**Consultation Response from KC,
Highways Development Management**

2025/92737 rear of, 23 to 43, Moor Lane, Gomersal, Cleckheaton, BD19 4LF

Date Responded: 18-11-2025.

Highways Development Management comments.

Project	Proposed residential development at land off Moor Lane, Gomersal
Client	Binks Executive Homes, Blakeridge Mills, Batley
Dwg Title	(21942)10_Access Road Elevations
Scale	1: 100 @ A2
Date	July 23

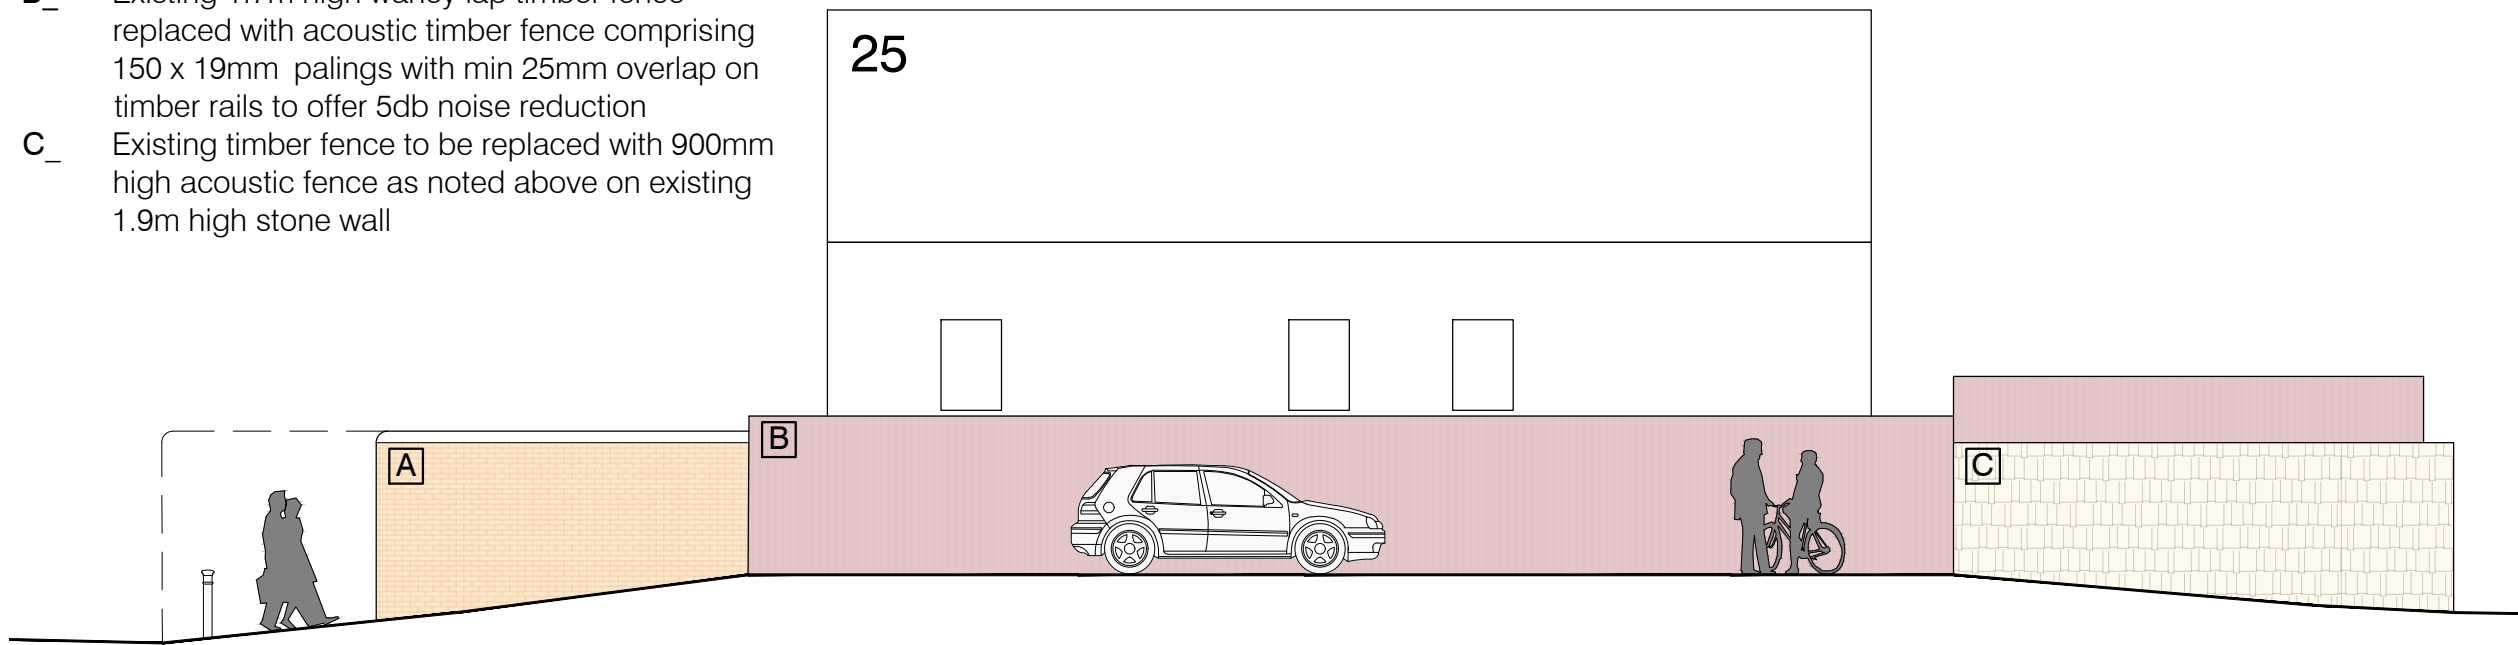
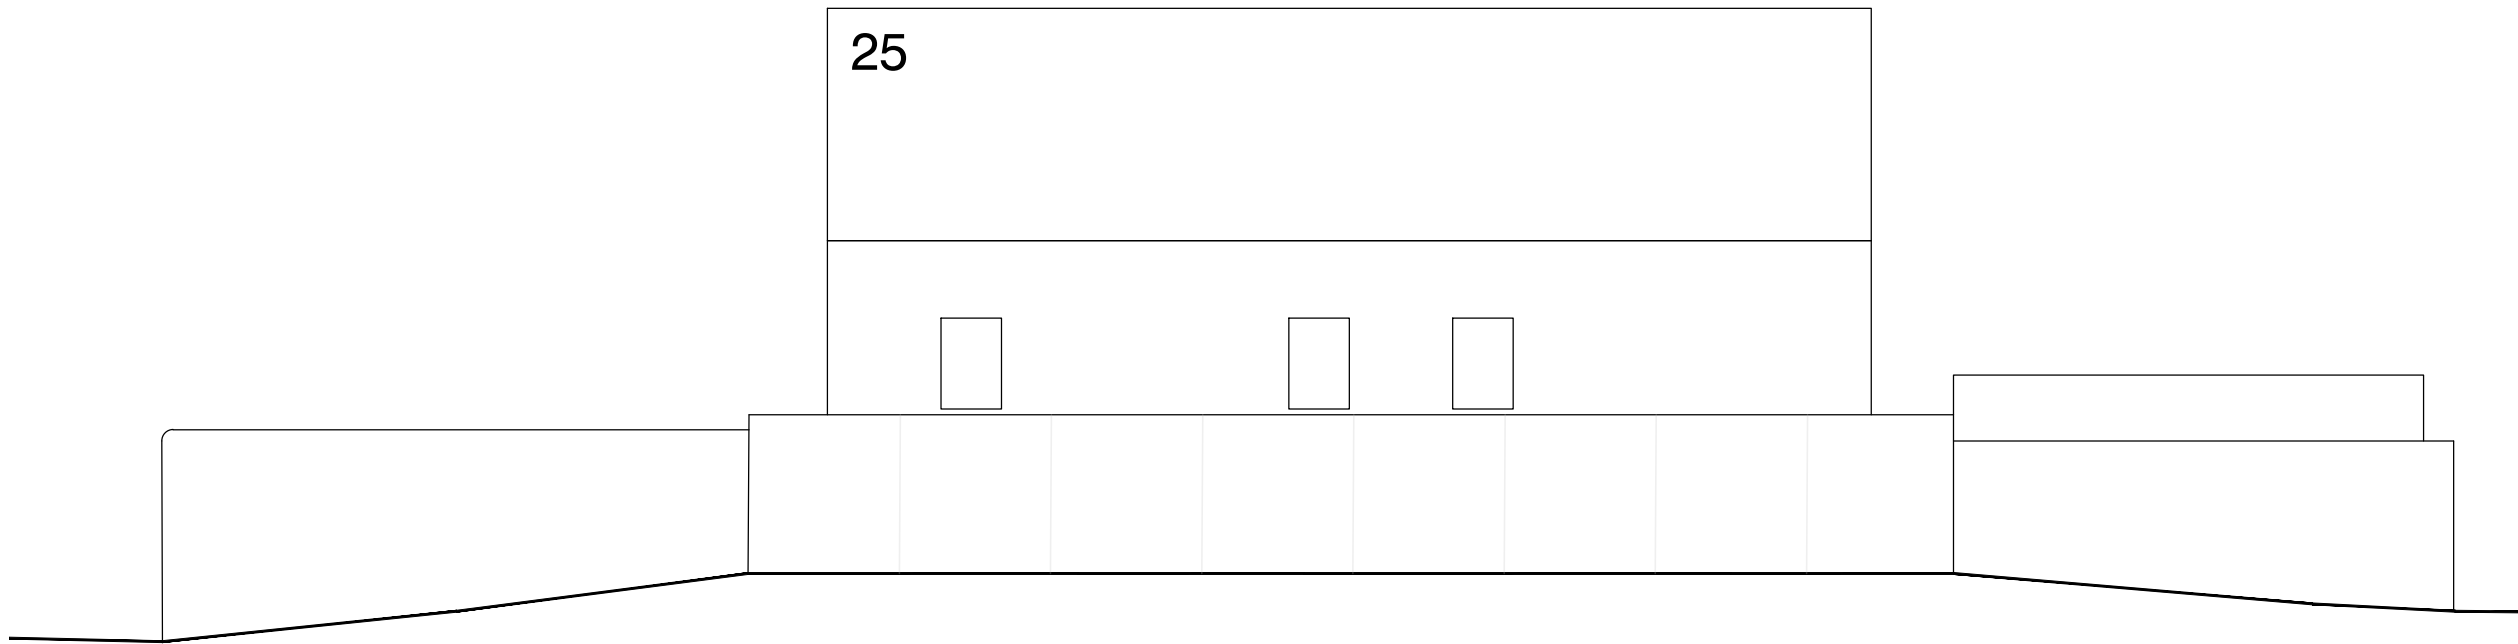
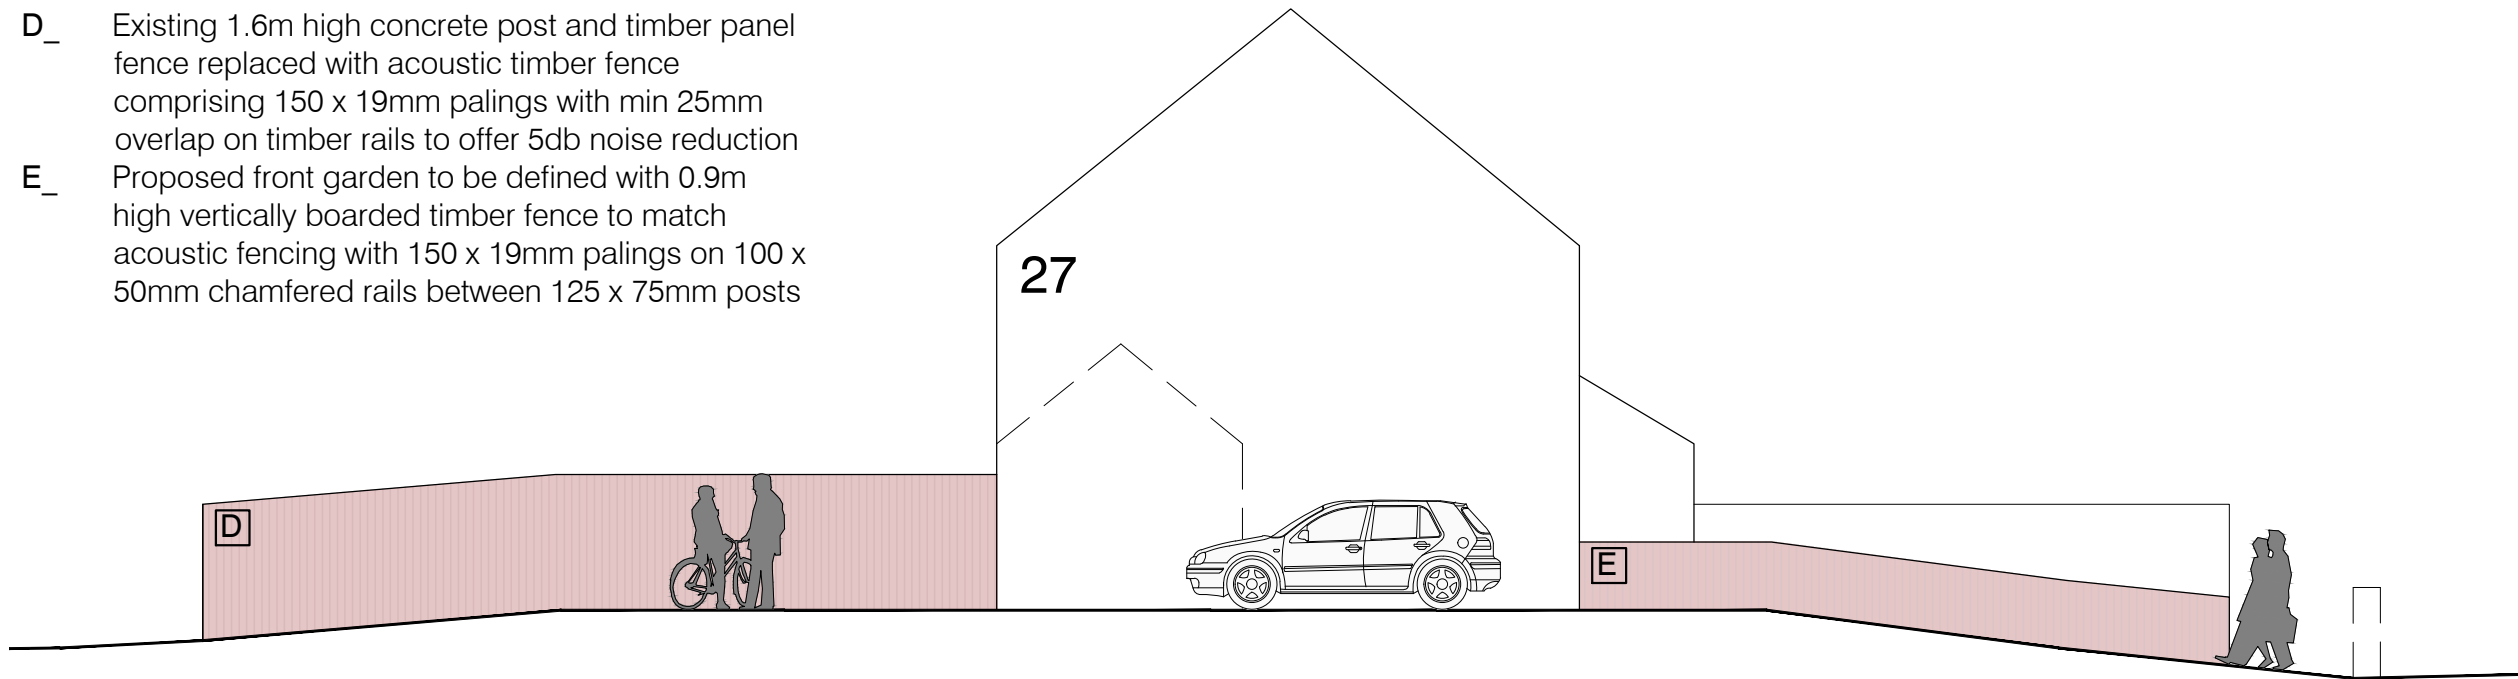
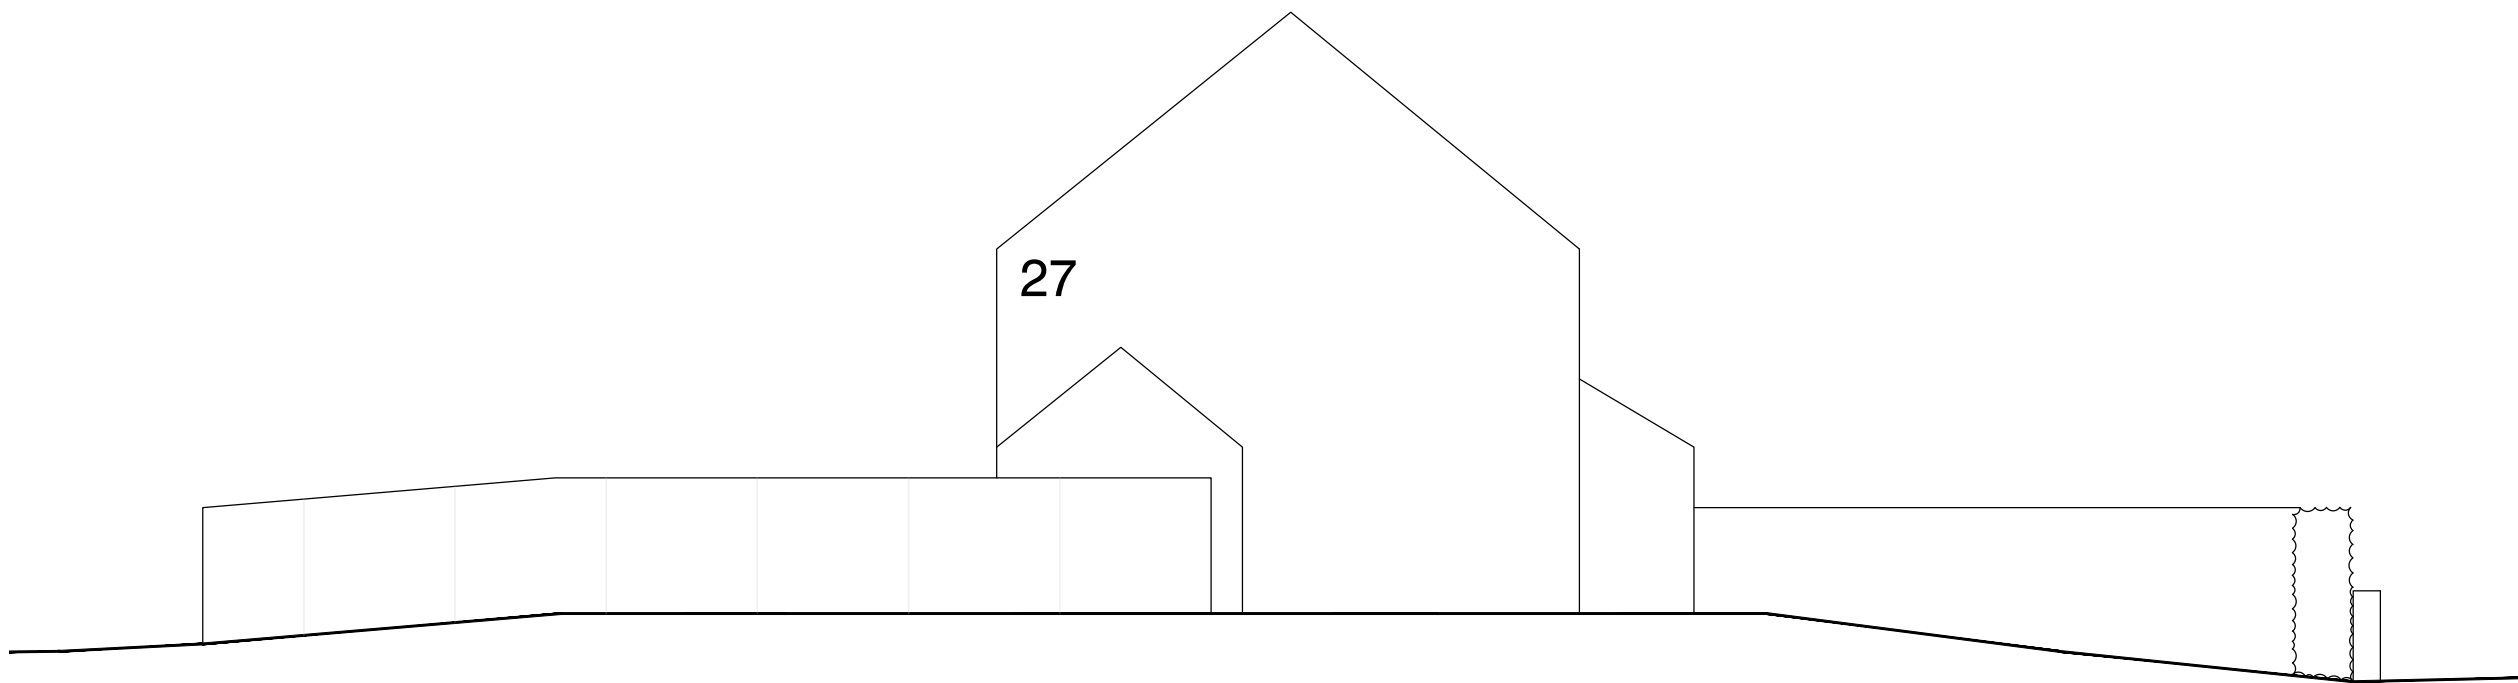
3, Works to the site frontage are shown as 278 works by others in accordance with Bryan G Hall 18-412-SKH-001 rev K. Plan number 18-412-SKH-001 rev K attached to the outline application does not show any construction details and these works are unlikely to be undertaken by others.
